This Response to Submissions Design Report has been prepared by Foster+Partners on behalf of the Pitt Street Developer North Pty Ltd to address the matters raised by government agencies, the public and community organisation groups during public exhibition of the proposed Sydney Metro Pitt Street North Over Station Development (OSD) State Significant Development (**SSD**).

The Department of Planning, Industry and Environment (**DPIE**) issued a letter to the applicant on the 26 August 2020, requesting a response to the comments raised during the public exhibition period for both the Concept SSD DA Modification application (**SSD-8875-Mod-1**) and the Detailed SSD DA (**SSD-10375**).

Comparison overshadowing to Park Regis Tower

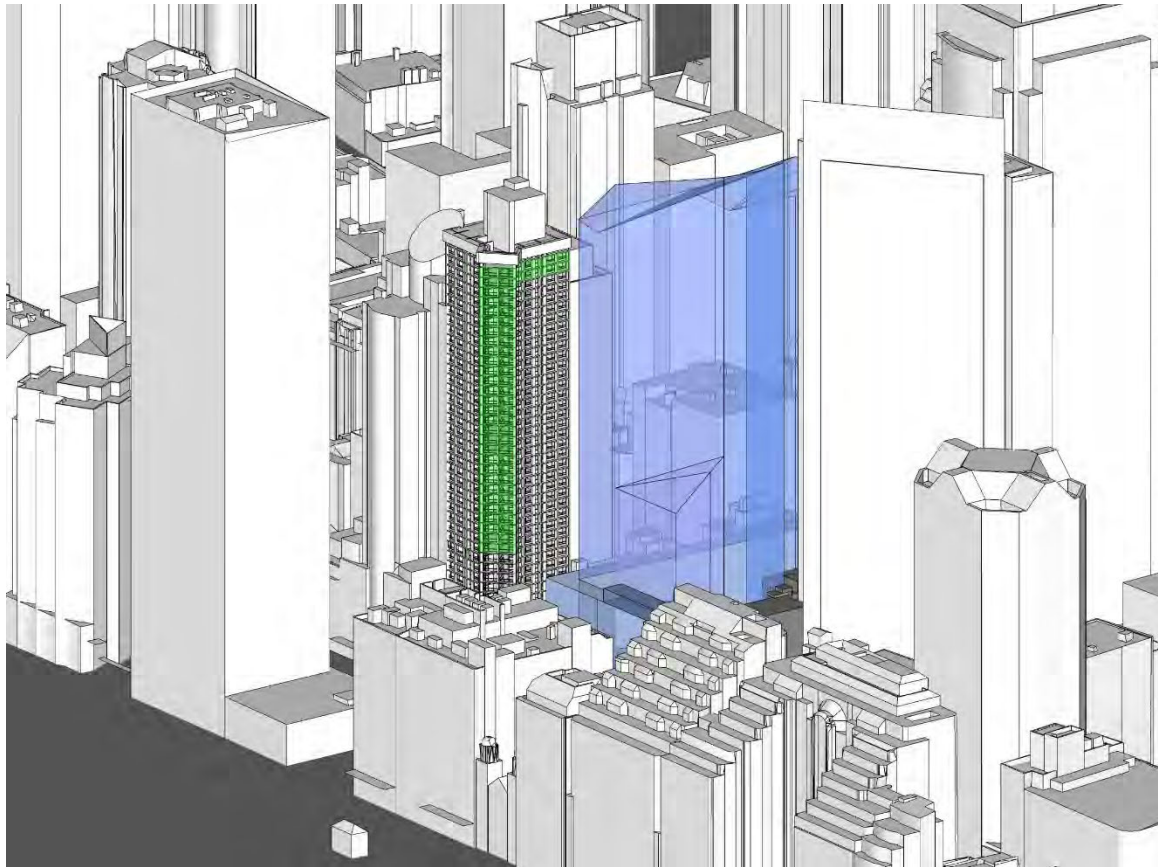
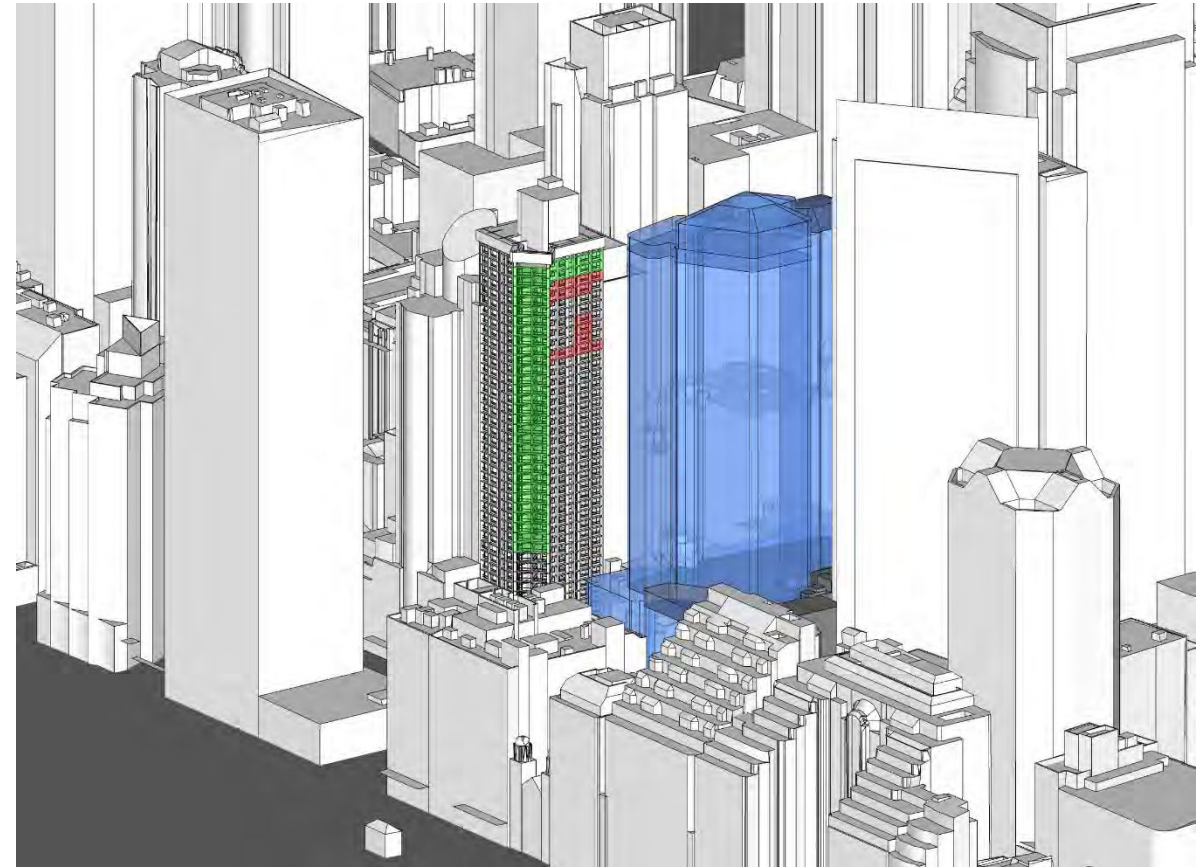
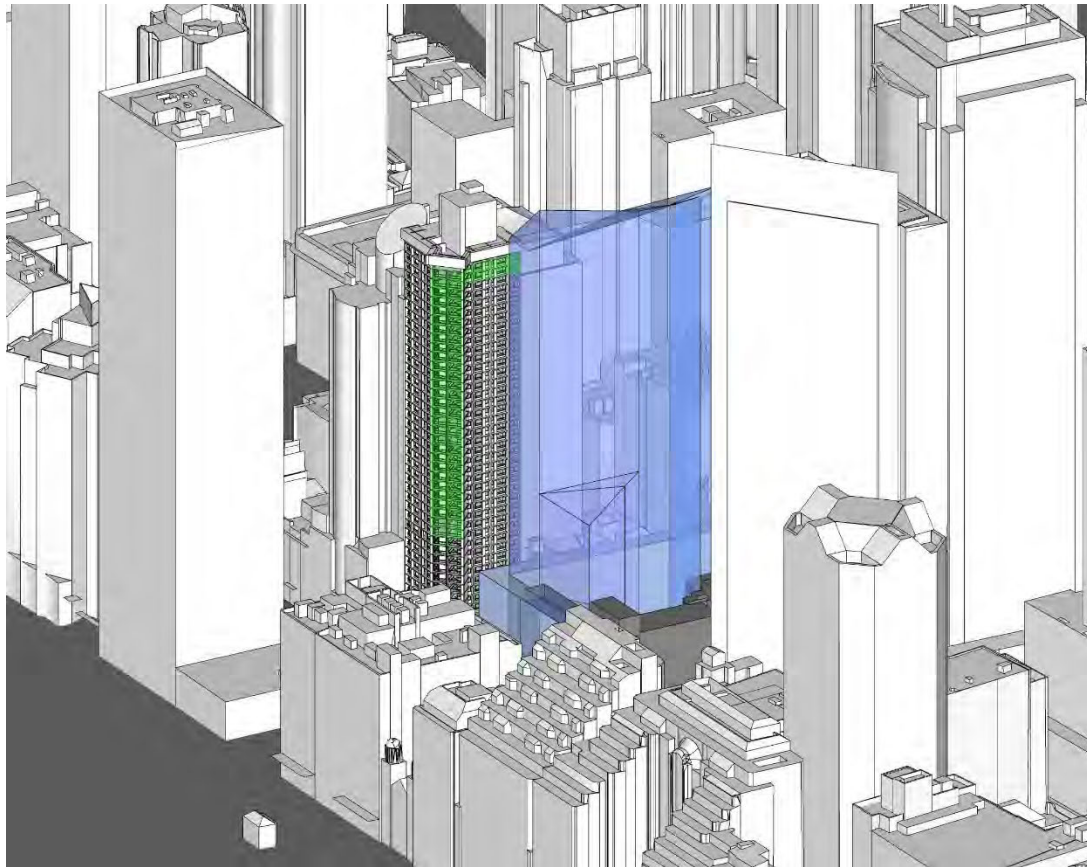
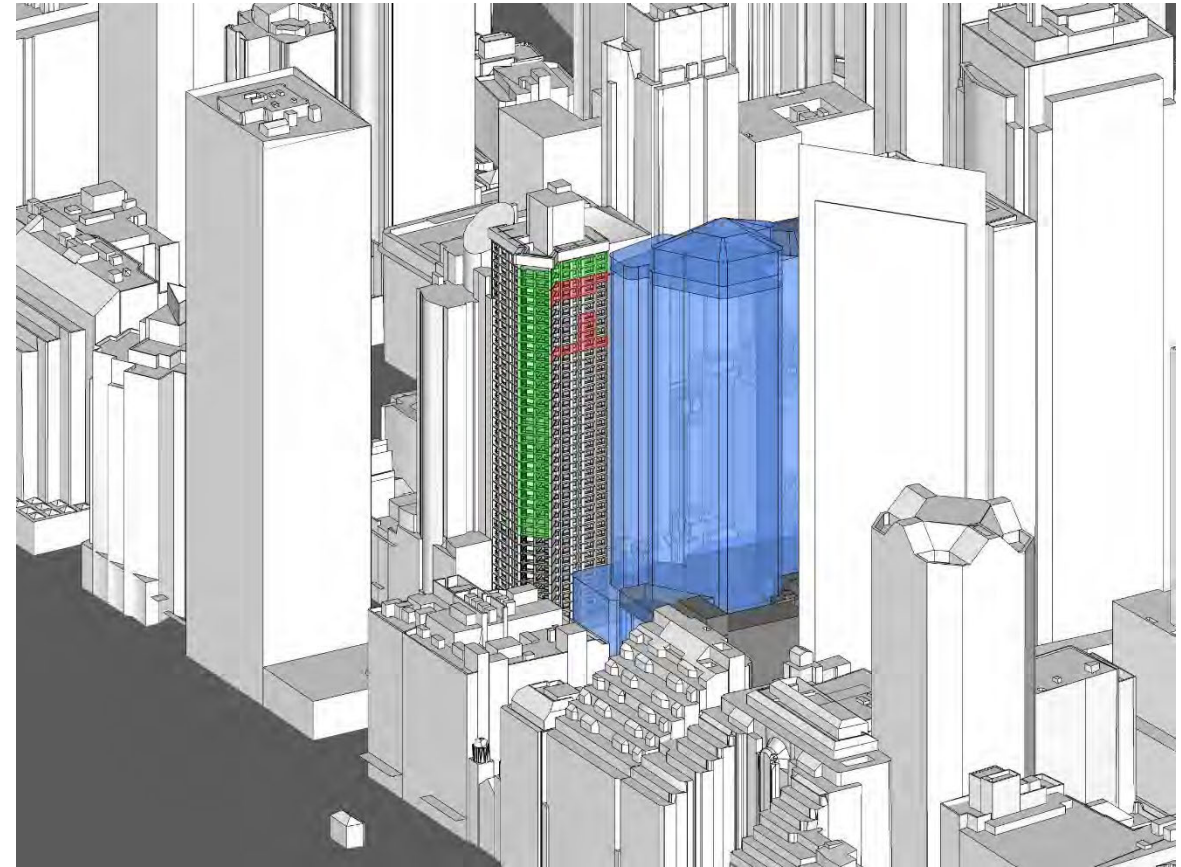
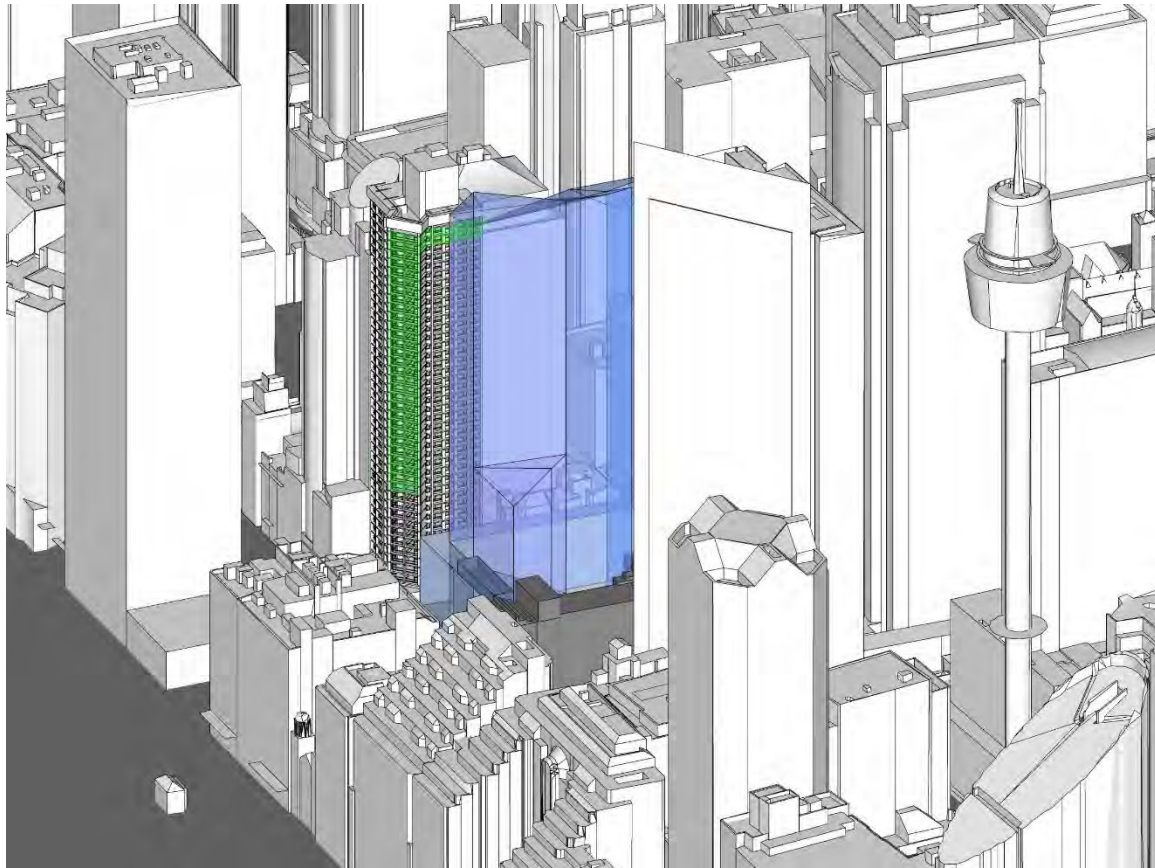
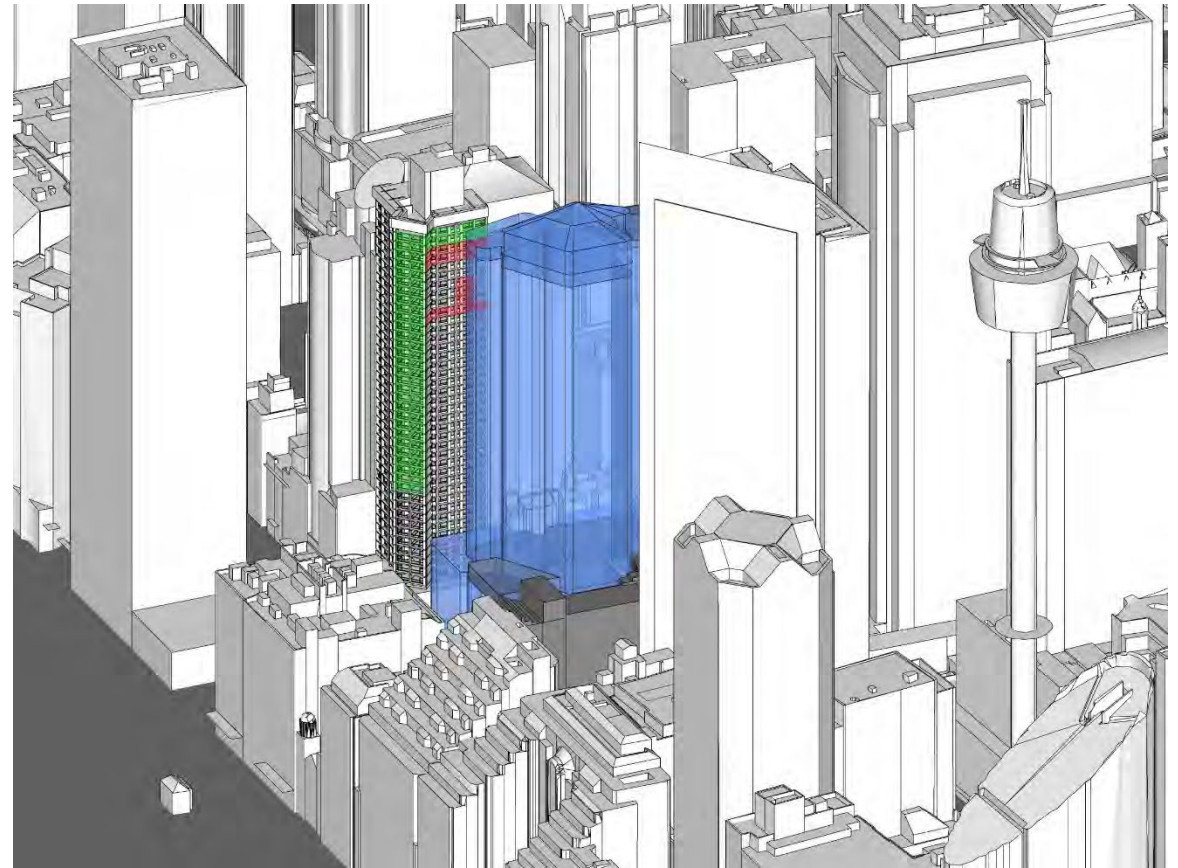
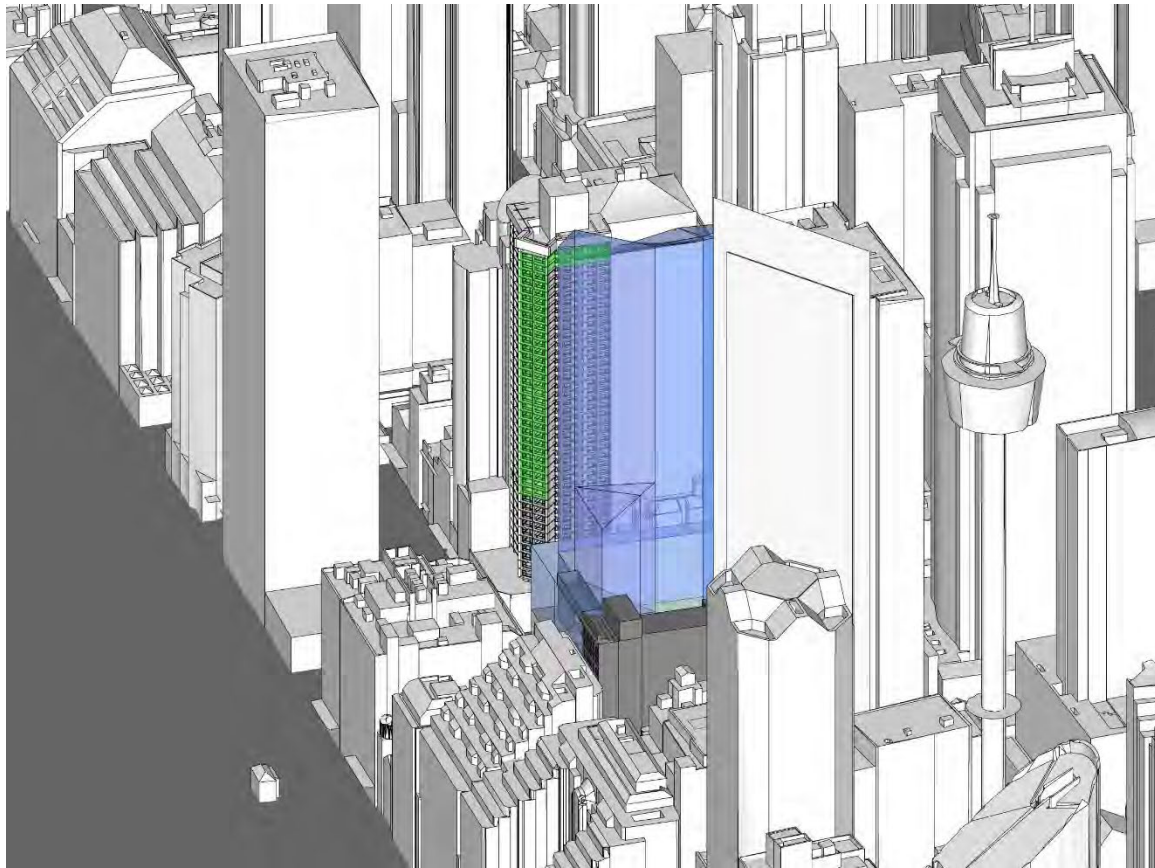
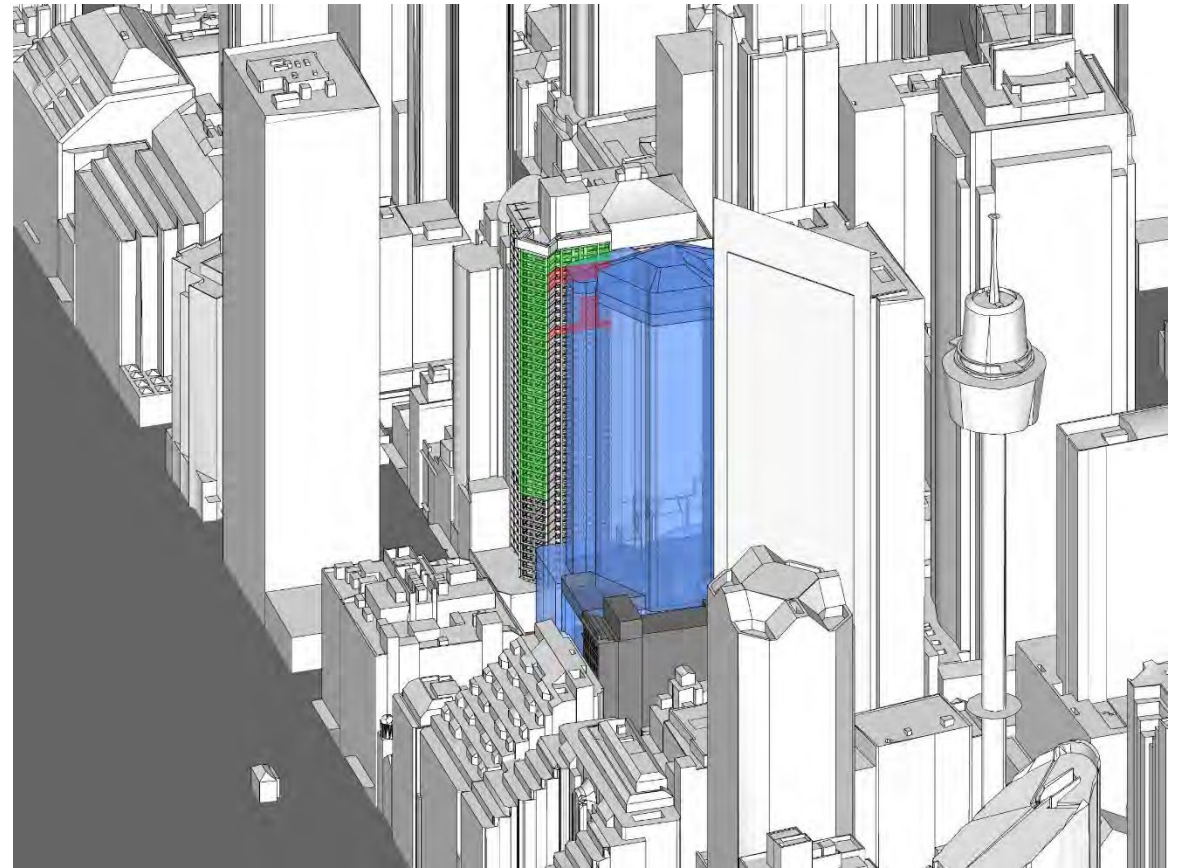
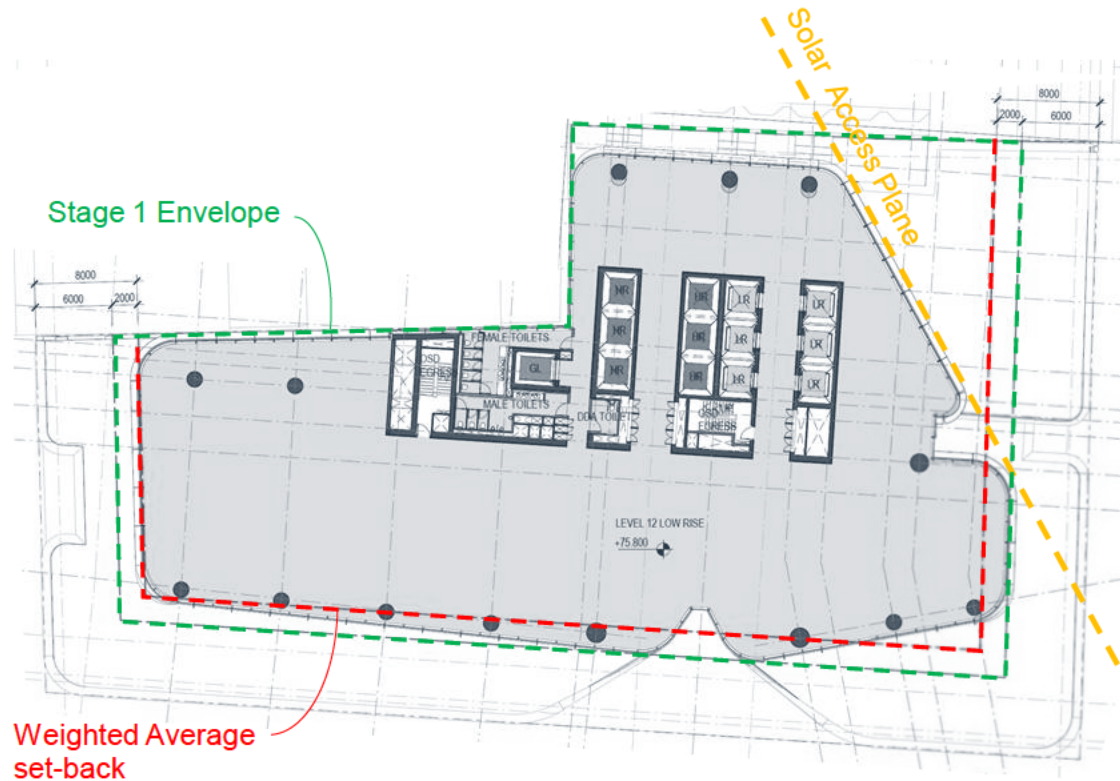
**(9.c) Minimise overshadowing impacts to surrounding residences, including private residences at 27 Park Street (Park Regis).**

The overshadowing impact of the SSDA proposal increases this proportion to 61/182 (33.5%) in comparison to the Approved Stage 1 envelope merely achieving 54/182 (29.7%), of an overall improvement of 13% (7 additional apartments).

Based on the above and when looking at the hours of 8AM - 4PM, solar compliance within the Park Regis residential tower increases from 129/182 (70.9%) to 154/182 (84.6%), which is an overall improvement of 19.4% (resulting in 25 additional apartments achieving SEPP 65 / ADG compliance for direct sun access) which is compliant with the objective 3B-2 of the ADG.

L10/11 Tower Facade impression – SW corner

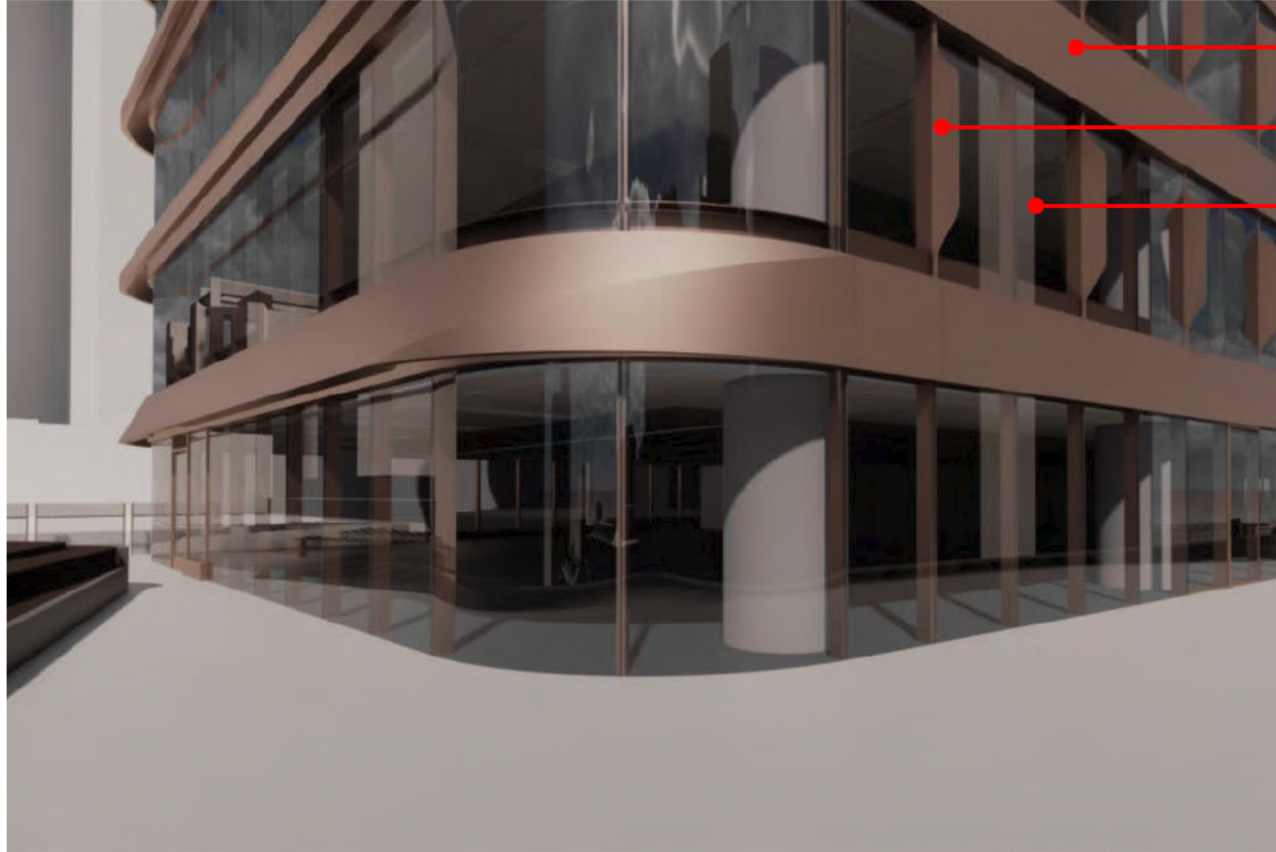
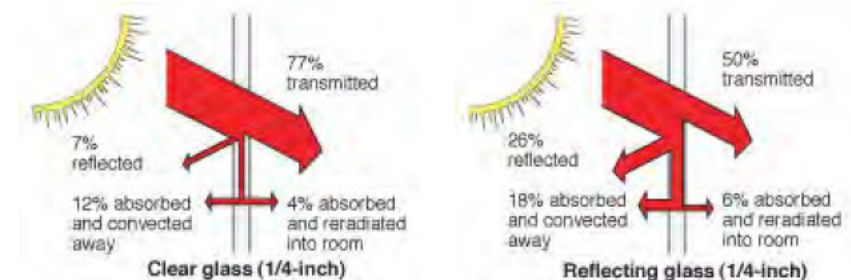
***The City requests the applicant provide details of a localised translucent glazing treatment that will ensure the glazed screen is visible to birds, particularly any threatened or vulnerable species and species of local conservation significance (refer to the City's Urban Ecology Strategic Action Plan).***
